Please upload the attached revised plans from the applicant onto Ocella for BN/129/19/PL.

I have gone through all of the plans you submitted with the application BN/129/19/PL for Land to the rear of Lillies, Yapton Road, Barnham and you need to submit the following:

Location Plan

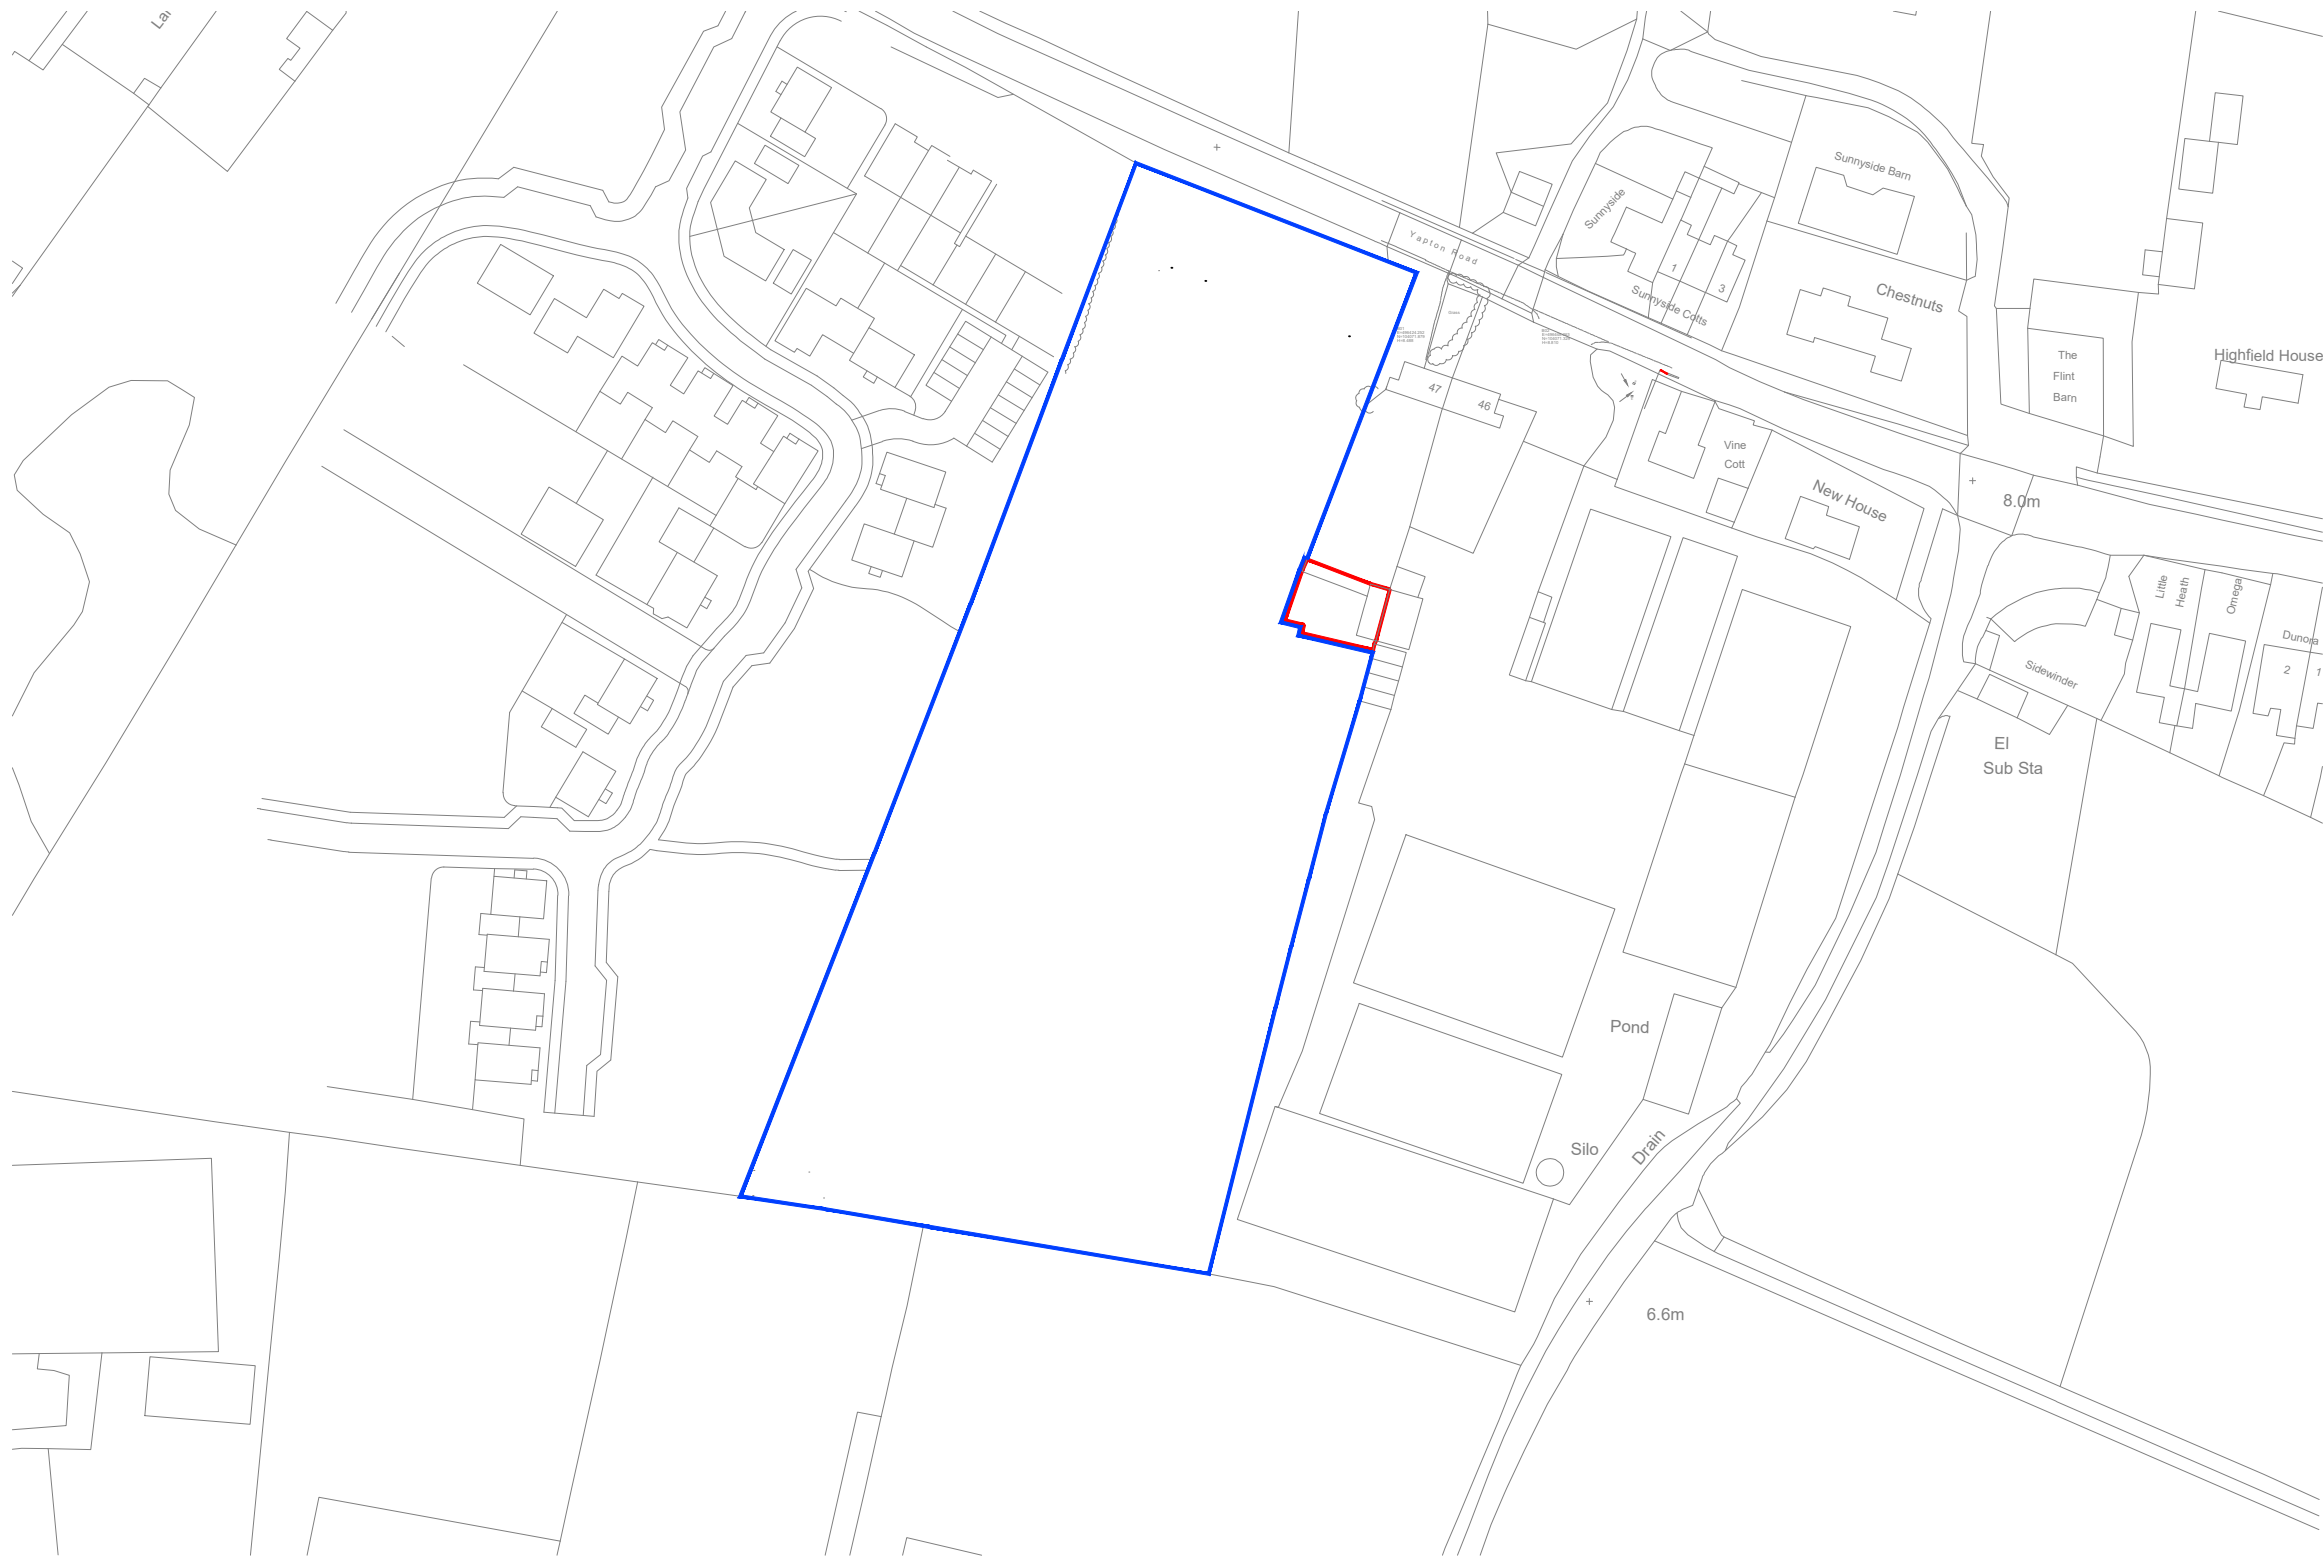
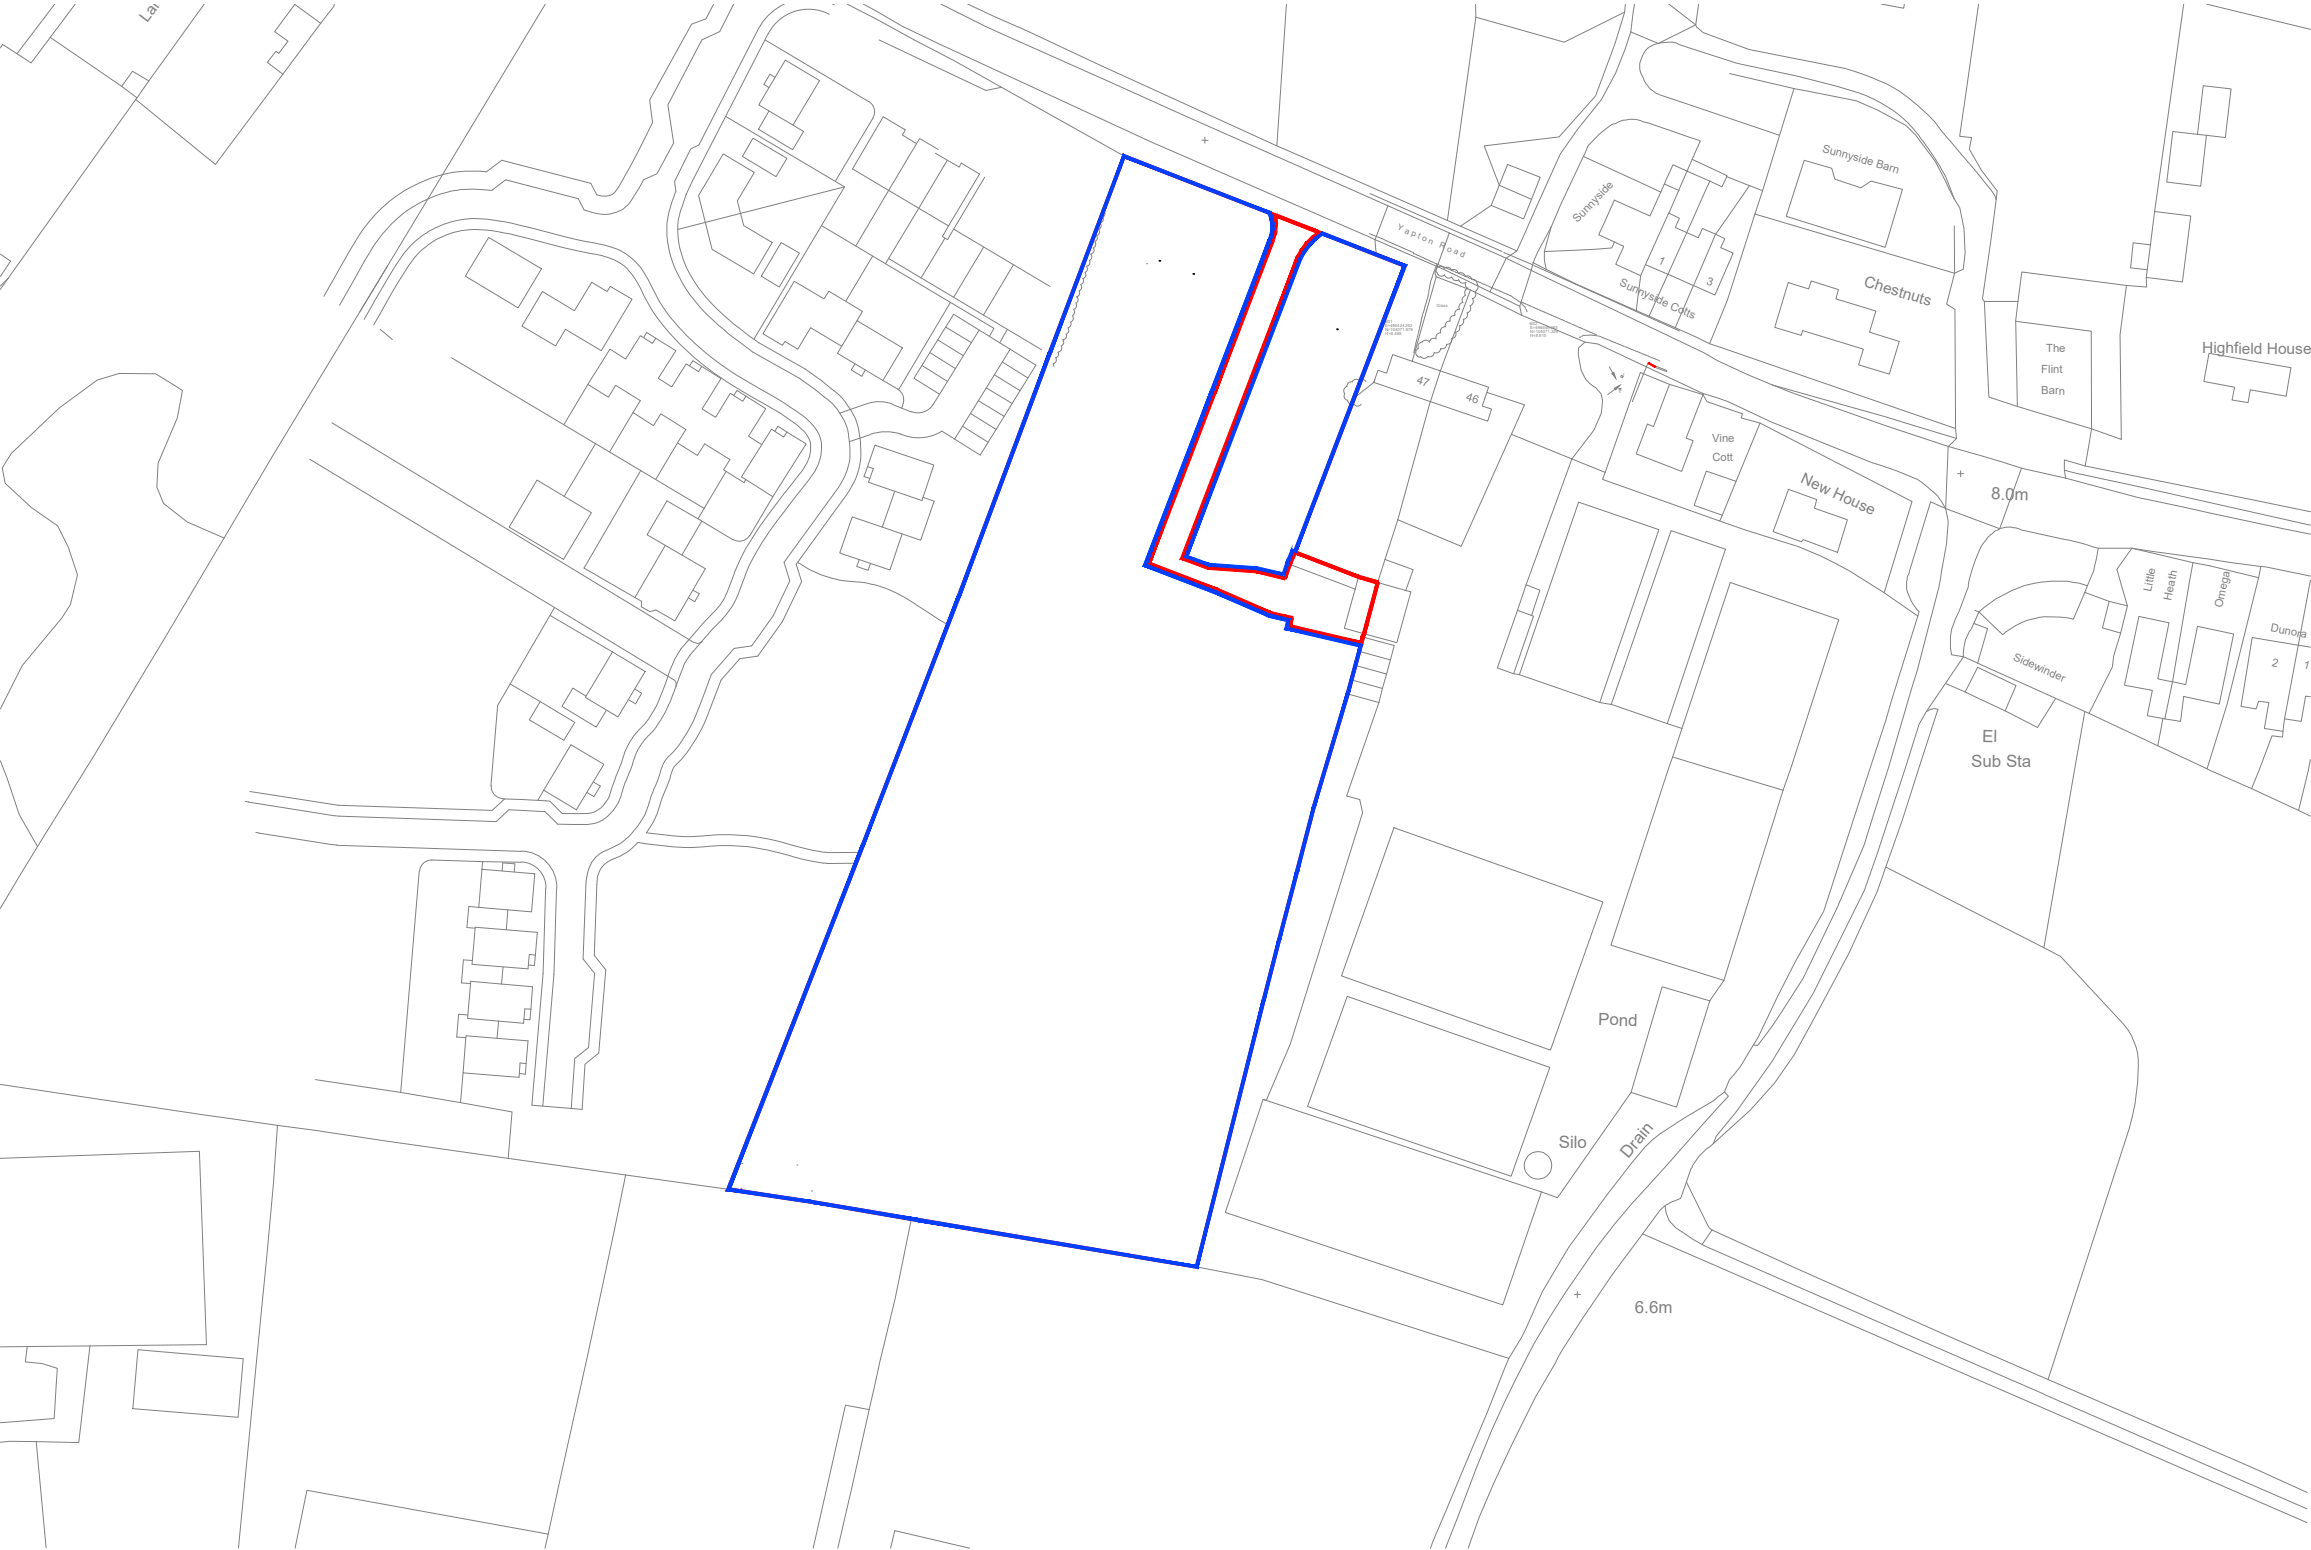
- A red line plan needs to include the site access onto Yapton Road.
- Any changes to the plots on 3, 4, 5, 6 and 7 in addition to the re-location of the double garage and the parking spaces for plots 4 and 5 need to be set out and included within the red line plan and the layout plan.
- What is happening to the additional tract of land to the north of the double garage which is within the red line boundary?
- A Deed of Variation is required to the Section 106 Agreement to include the details of the new application BN/129/19/PL.

Please see attached the adjusted site layout and location plan with the red and blue line adjusted. Please be so kind and let me know if this is what is required.
